File No: SF17/34879  
Ref No: DOC17/340252

**RE: Environmental Impact Statement Review – The Northern Road Upgrade: Mersey Road, Bringelly to Glenmore Parkway, Glenmore Park, State Significant Infrastructure Project (SSI 7127).**

**Appendix N – The Northern Road Upgrade Mersey Road, Bringelly to Glenmore Parkway, Glenmore Park, Technical working paper: Non-Aboriginal Heritage Assessment** prepared by Jacobs, June 2017

Figure 7-2 | Location of Chaffey Brothers Irrigation Scheme Canal (Item 2) in relation to proposed works

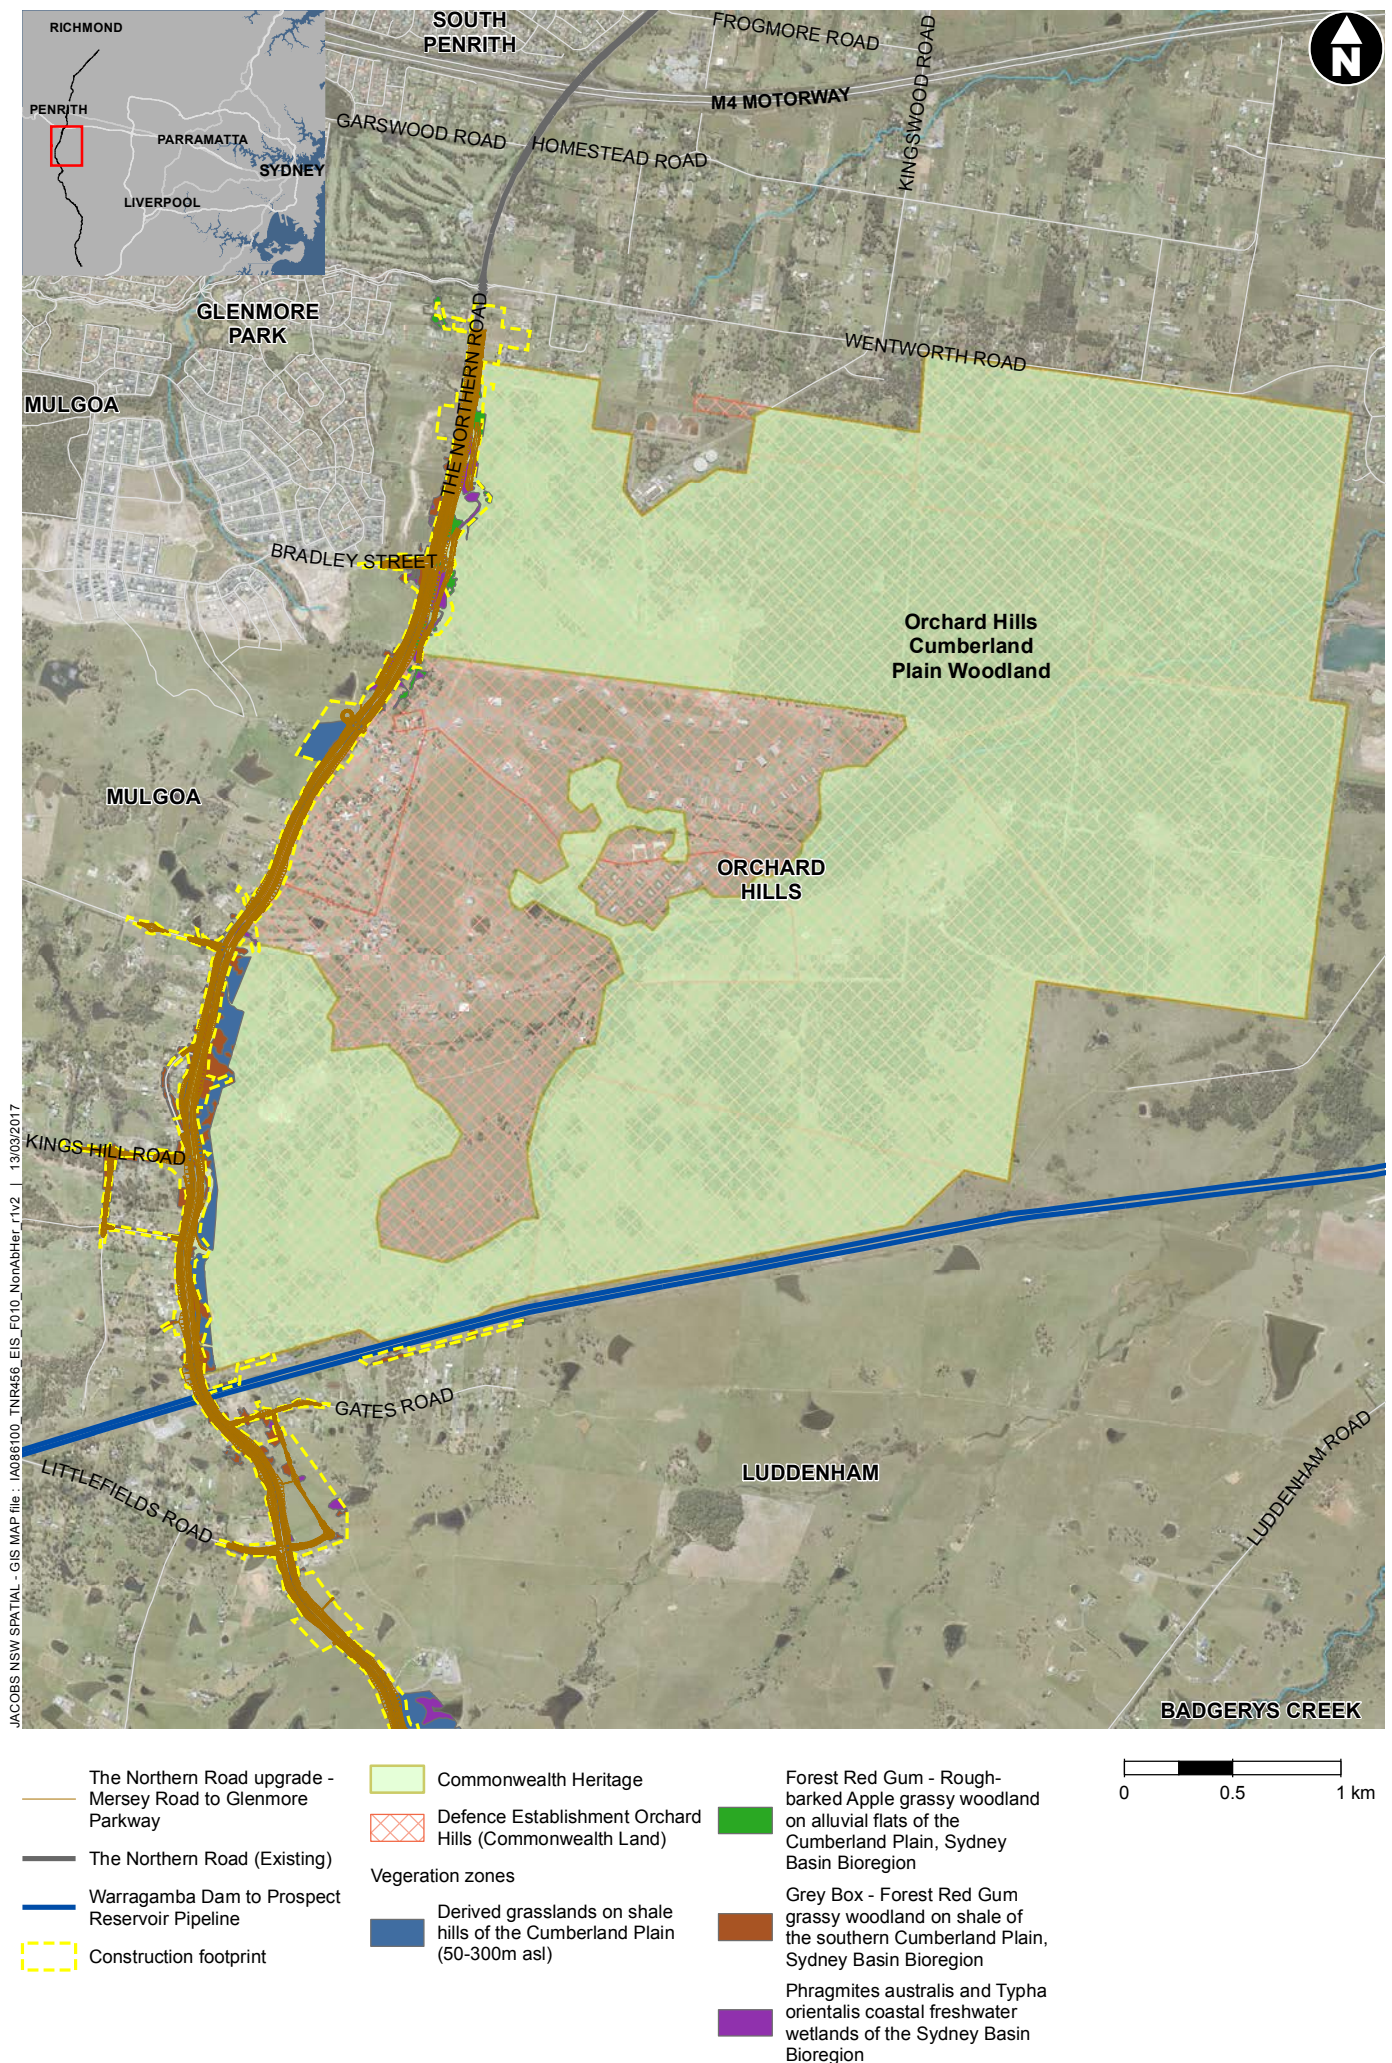
The Chaffey Brothers Irrigation Scheme canal (also associated with the Mulgoa Irrigation scheme) is assessed by GML Heritage as retaining high significance. This canal system is described as series of shallow depressions in poor condition with some wooden beams noted in association with them. It is unclear how the impacts on the canal, from the northern section of the proposed road upgrade, would be mitigated other than by proposed archival recording. This may be a suitable mitigation option however, the discussion has not stated what the Heritage Management Plan prepared by GML Heritage has advised about the section of the canal. It would be appropriate for the mitigation to reference this HMP to justify the approach proposed.

Information to clarify how the proposed mitigation measure of archival recording complies with the advice in the Heritage Management Plan prepared by GML Heritage for management of this high significant item.

Figure 7-4 | Location of Miss Lawson's Guesthouse Site (Item 9) in relation to proposed works

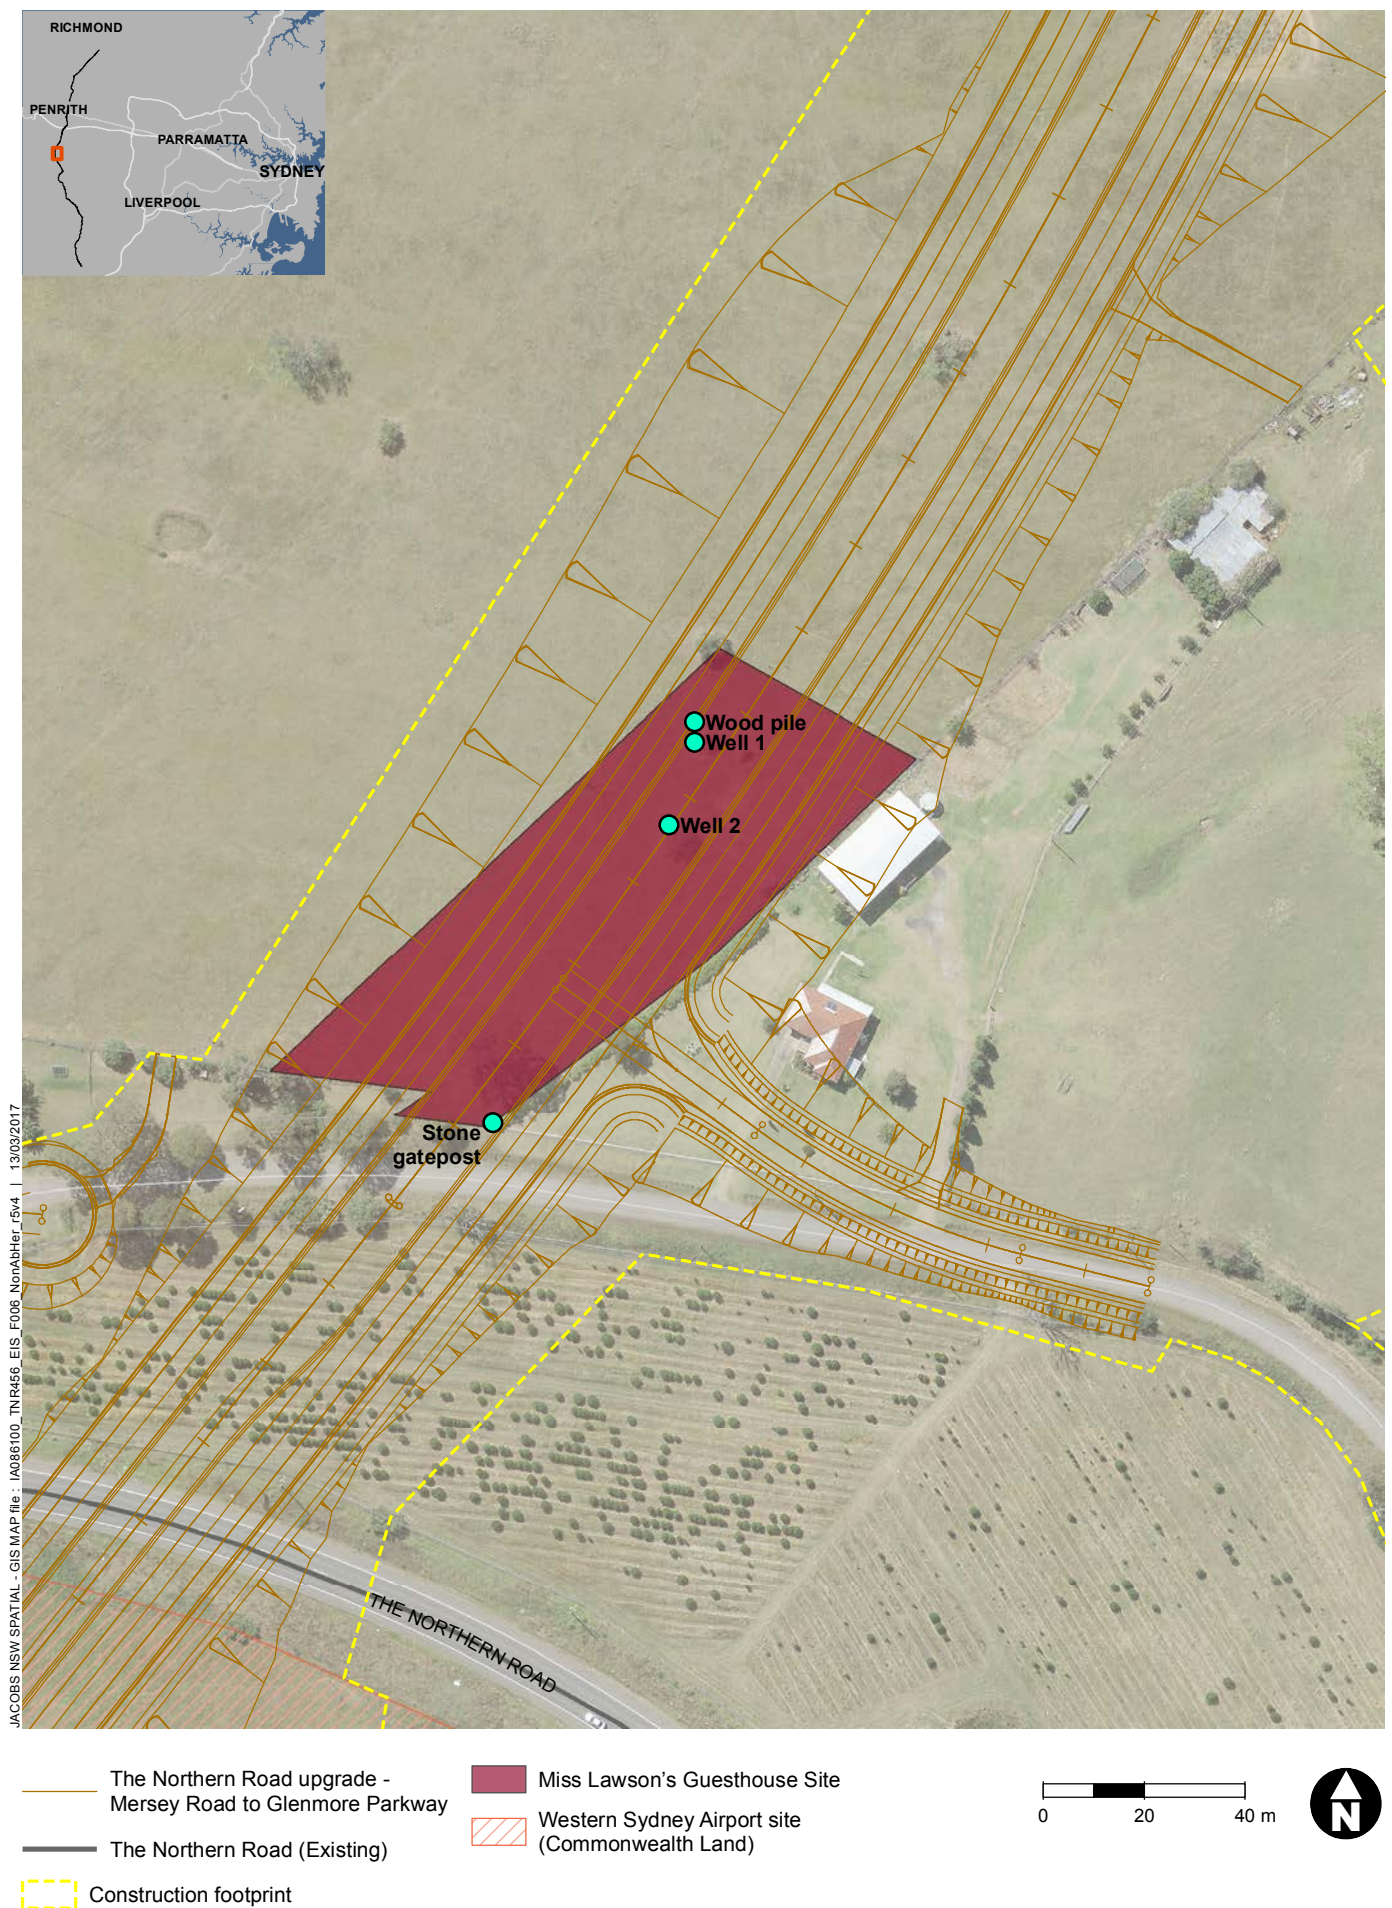
*Item 9 (Miss Lawson's Guesthouse site)* was associated with Item 10 (Lawson's Inn Site) and dates from the same time, circa 1830s. It would be fully impacted by the proposed works; the proposed approach is open area salvage of this archaeological site. It is noted the site may retain a higher level of significance than local, however the supporting assessment has been inadequate in demonstrating detailed site specific historical research and comparative analysis to support the significance assessment. Archaeological sites may satisfy multiple values under the significance criteria other than just Criterion 'e' for research potential. The mitigation is considered to be inadequate because it does not provide the detailed response required by the SEARS.

and Item 9 (Miss Lawson's Guesthouse site) by an historical archaeologist who has demonstrated experience in excavating and assessing sites of state heritage significance in the state of NSW.

Figure 7-5 | Location of Lawson's Inn Site (Item 10) in relation to proposed works

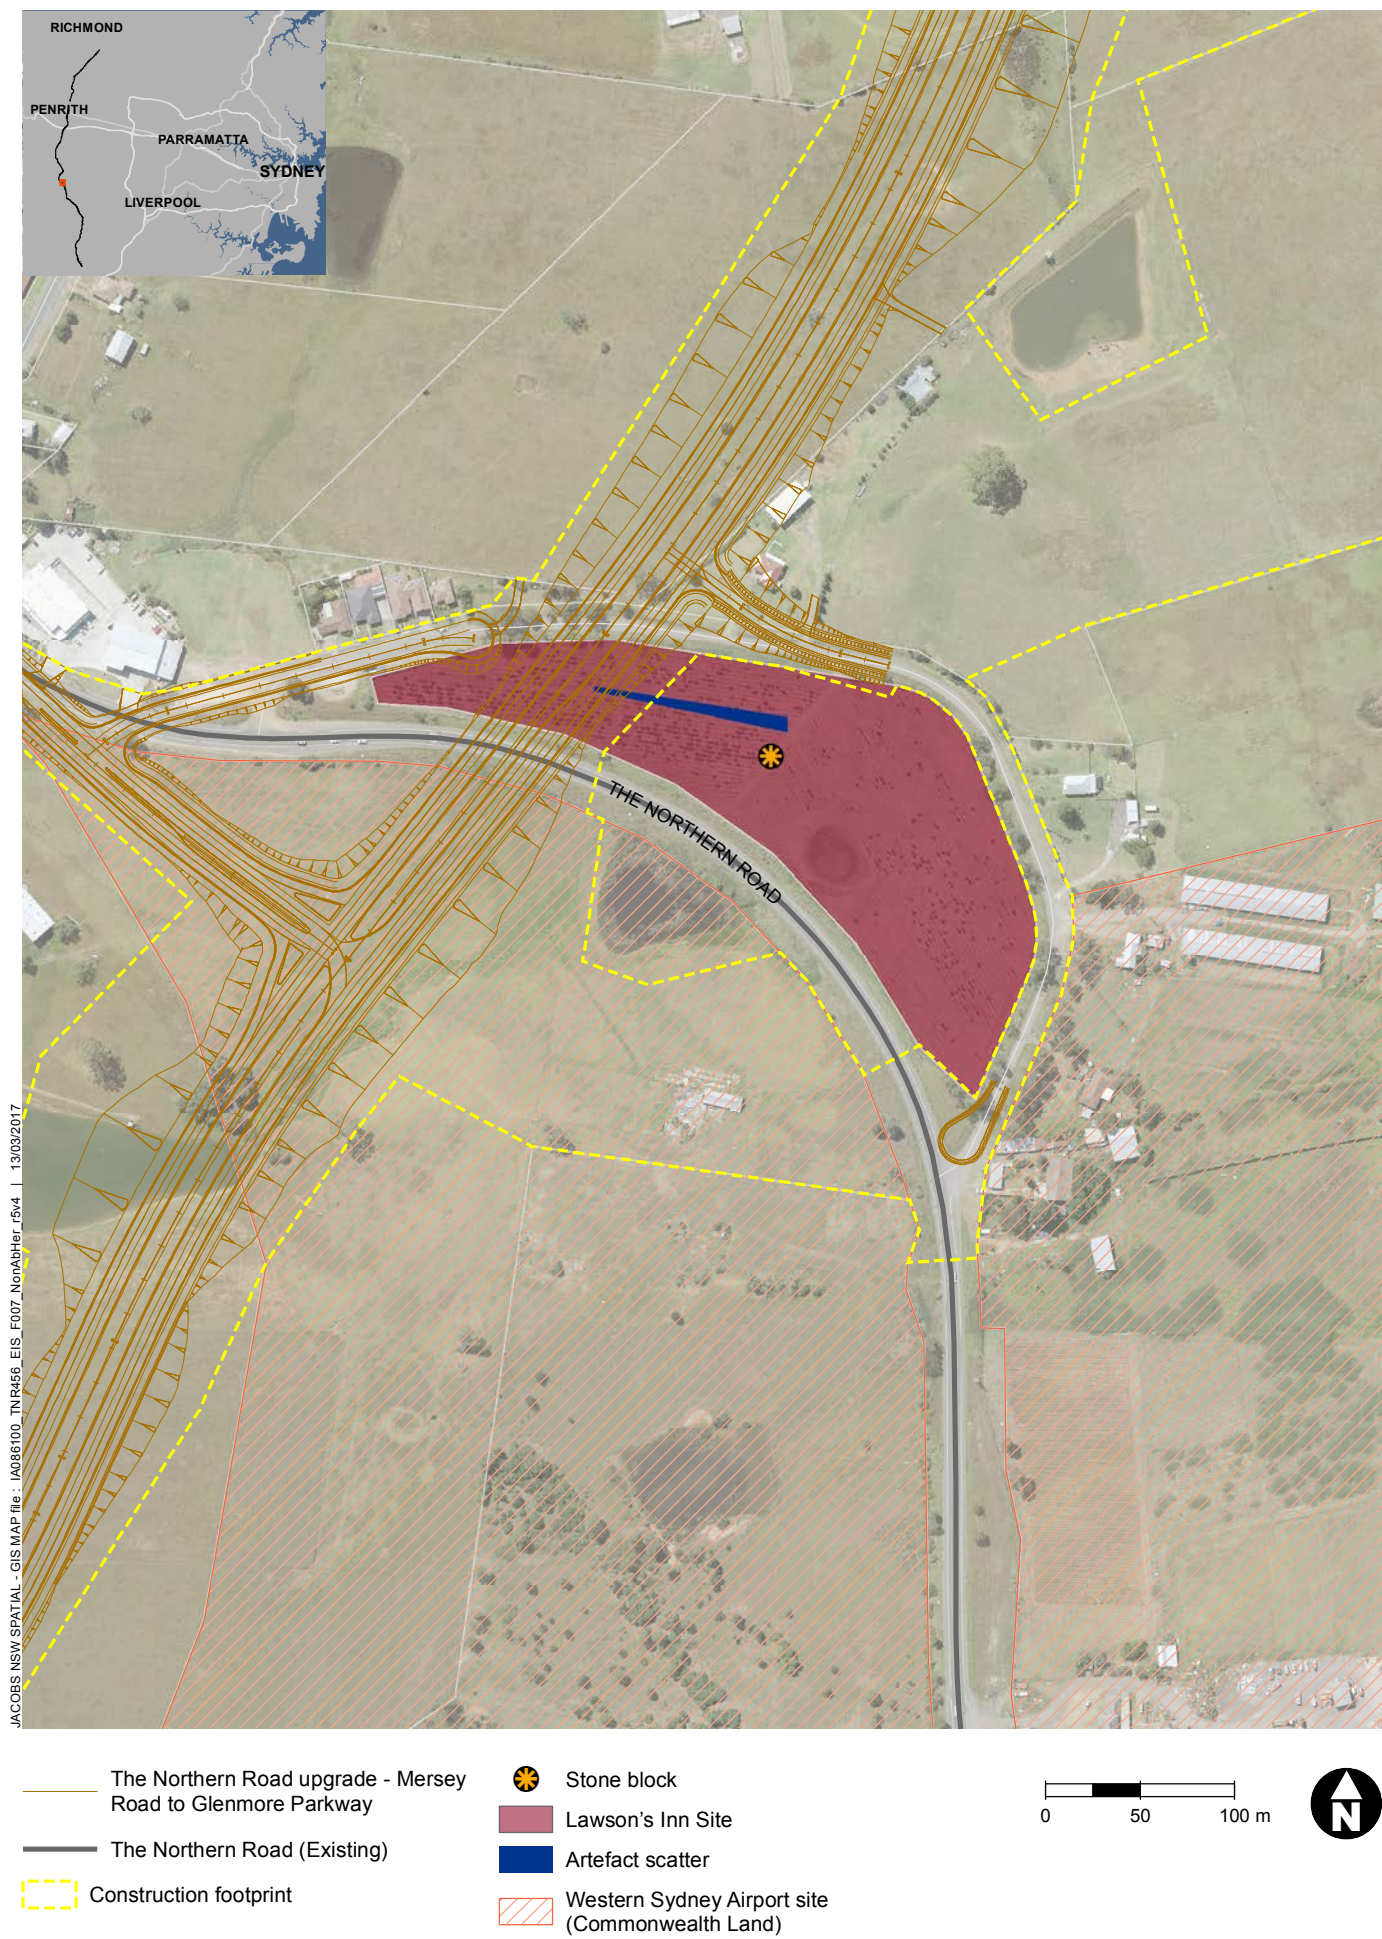
*Item 10 (Lawson's Inn Site)* is a circa 1830s inn site, and has been assessed previously as being of state significance, however, it has been argued that the site is of local significance. There is no justification for this change in significance for this item. The mitigation proposed is also unclear because the EIS has argued in Section 7 that full archaeological sites for Items 9 and 10 will be salvaged. However, the executive summary of the Appendix (Table 2, page xvi) specifically states 'around a quarter of the site (Item 10) would be directly impacted by construction'. Partial excavation of this site is not supported where full impacts may occur through construction and other associated activities which would represent indirect impacts as well as direct impacts. It is recommended this is resolved in the EIS as either completely avoiding the site or fully salvaging the site within an appropriate excavation methodology. The excavation would need to include a methodology an Archaeological Research Design and the nomination of an Excavation Director who meets the Heritage Council Criteria.
